MMC Congress Street Concept Plans

Tue, Feb 25, 2020 at 1:14 PM

Apologies for the delay on this. Please see comments on these revised plans below.

CONGRESS STREET

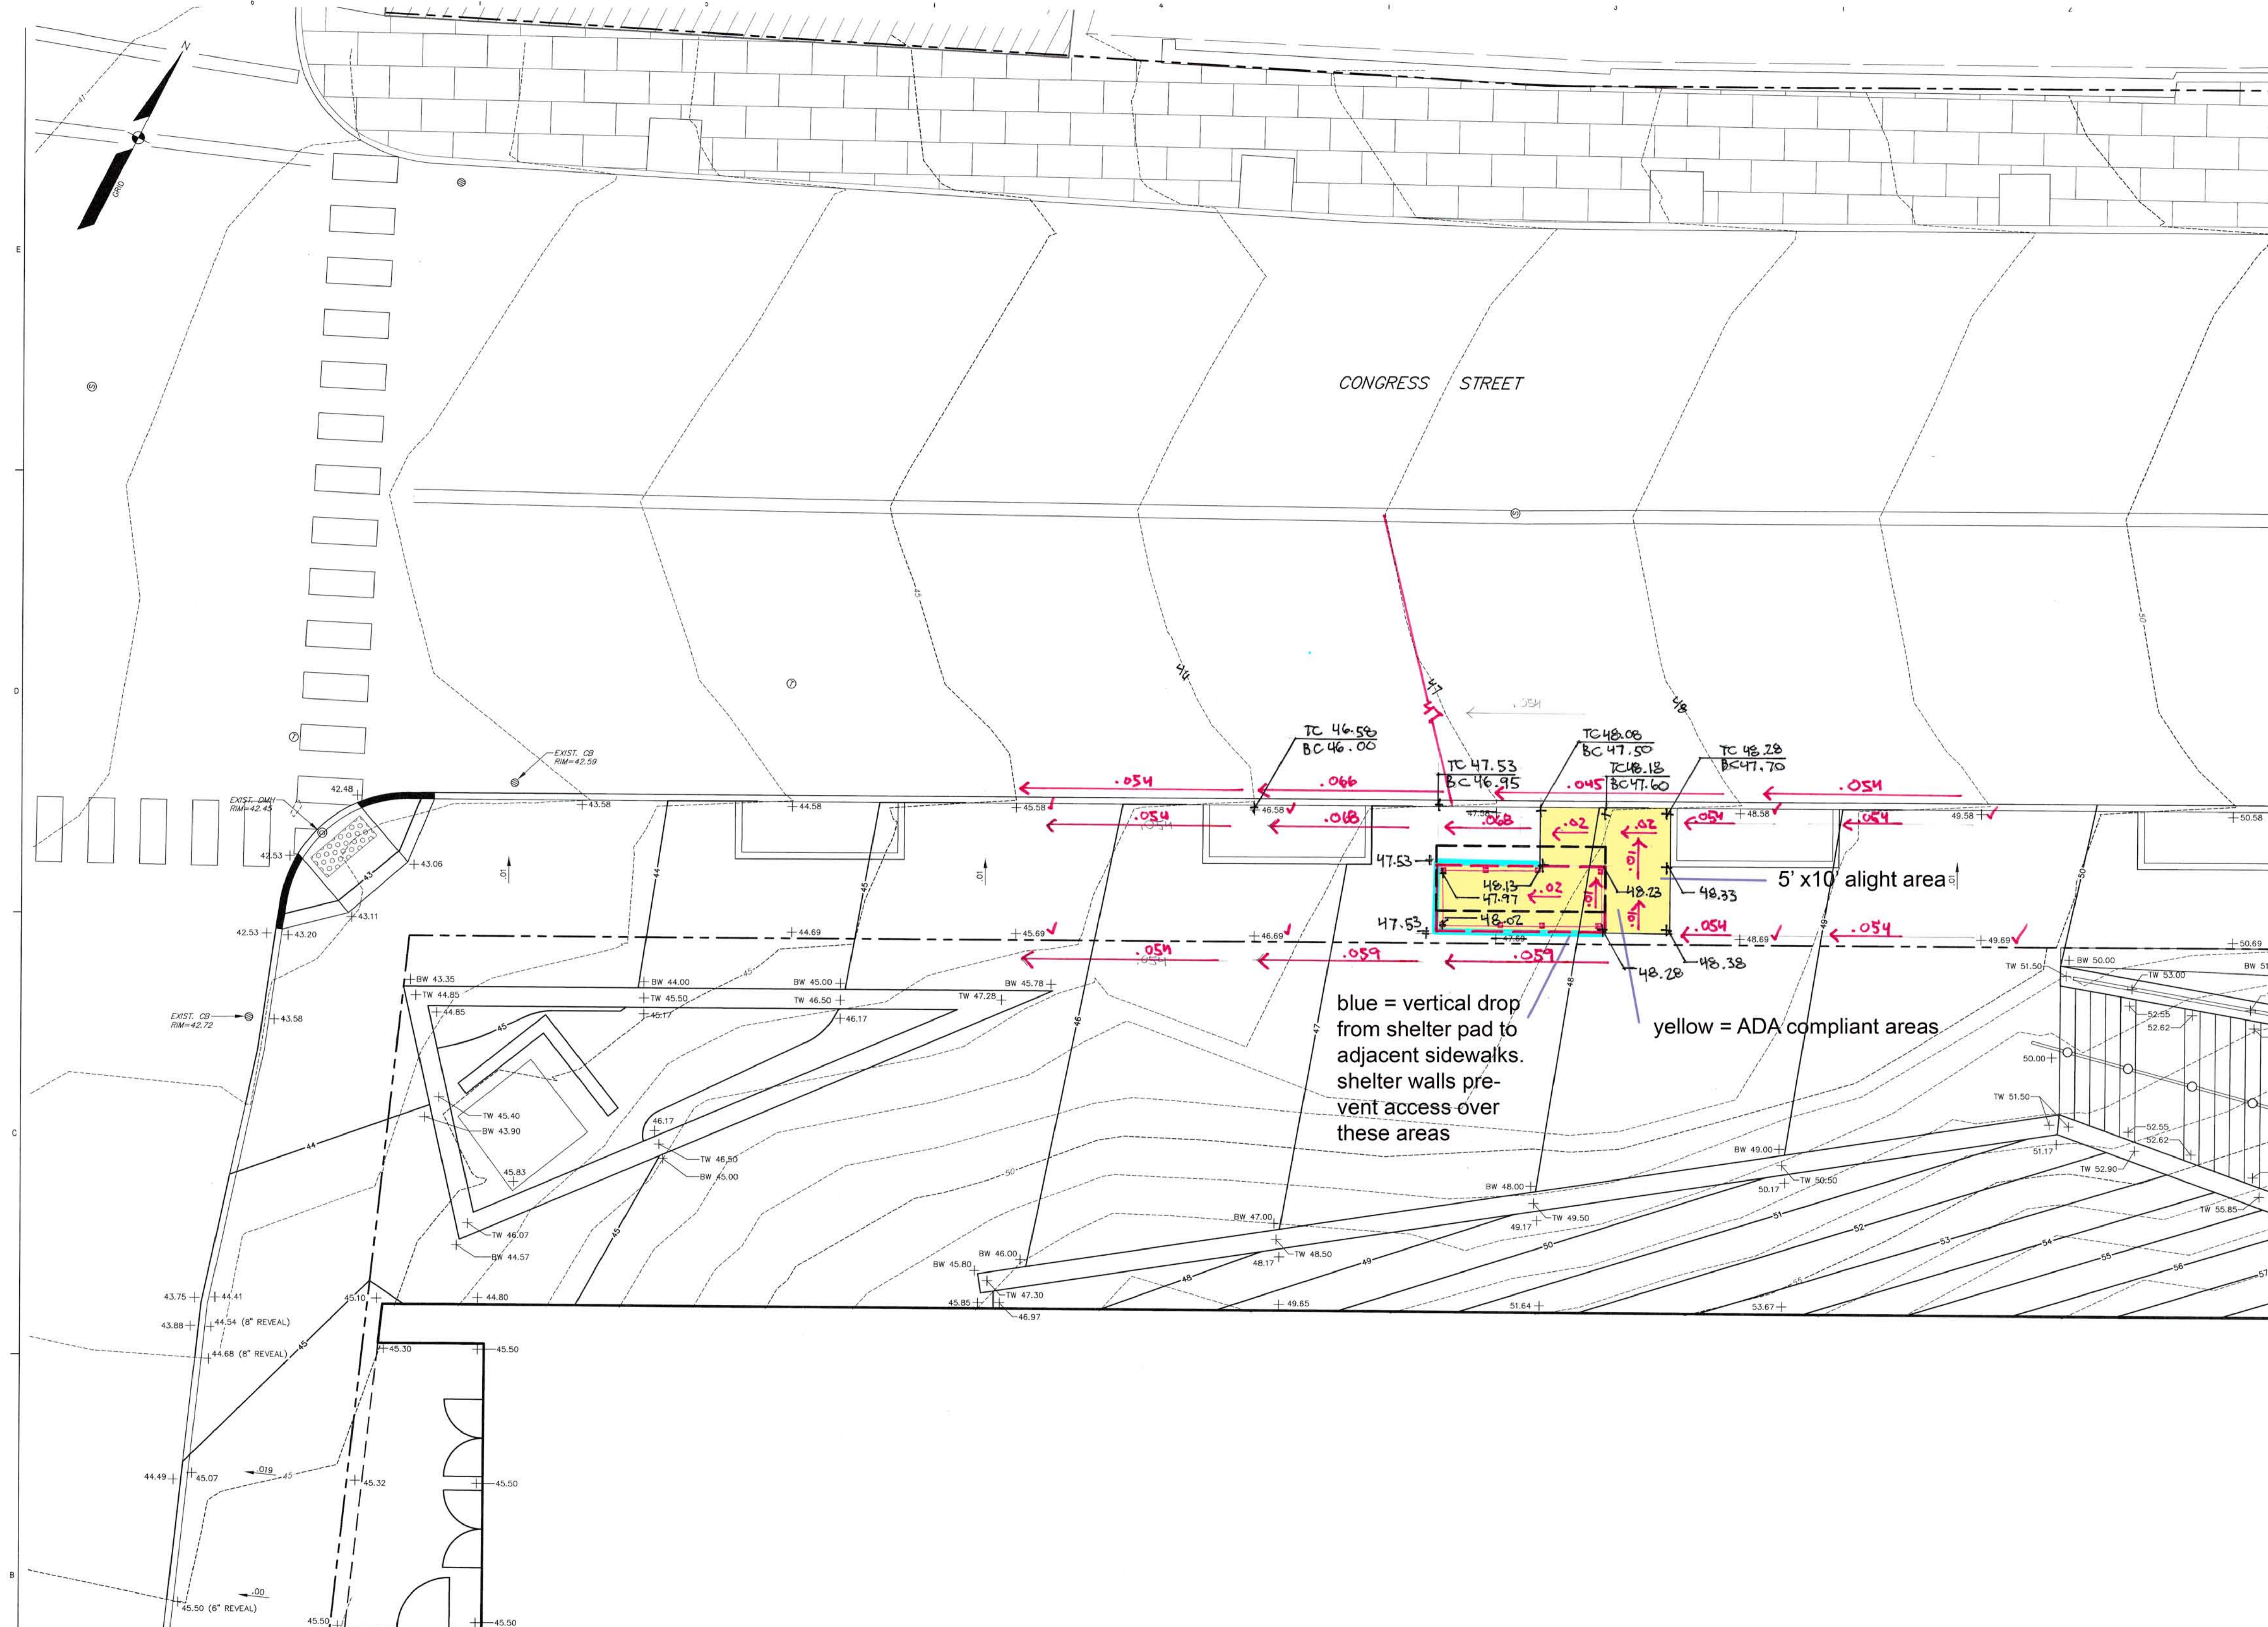
- The sidewalk along the south side of Congress Street must provide at least 5 feet of width around the bus stop within the right of way. In order to provide this, the southern curb line must shift northward by 4 feet, more in keeping with the Planning Board-reviewed plans. This will allow for a cross section of a 9-foot parking lane, two 10.5-foot travel lanes, and two 6-foot bicycle lanes. In keeping with the curb realignment, at Gilman Street, the left-turn lane should be eliminated. A small gore area (significantly smaller than previously shown, measuring about 4 feet at its widest), should be shown in this area as a replacement.
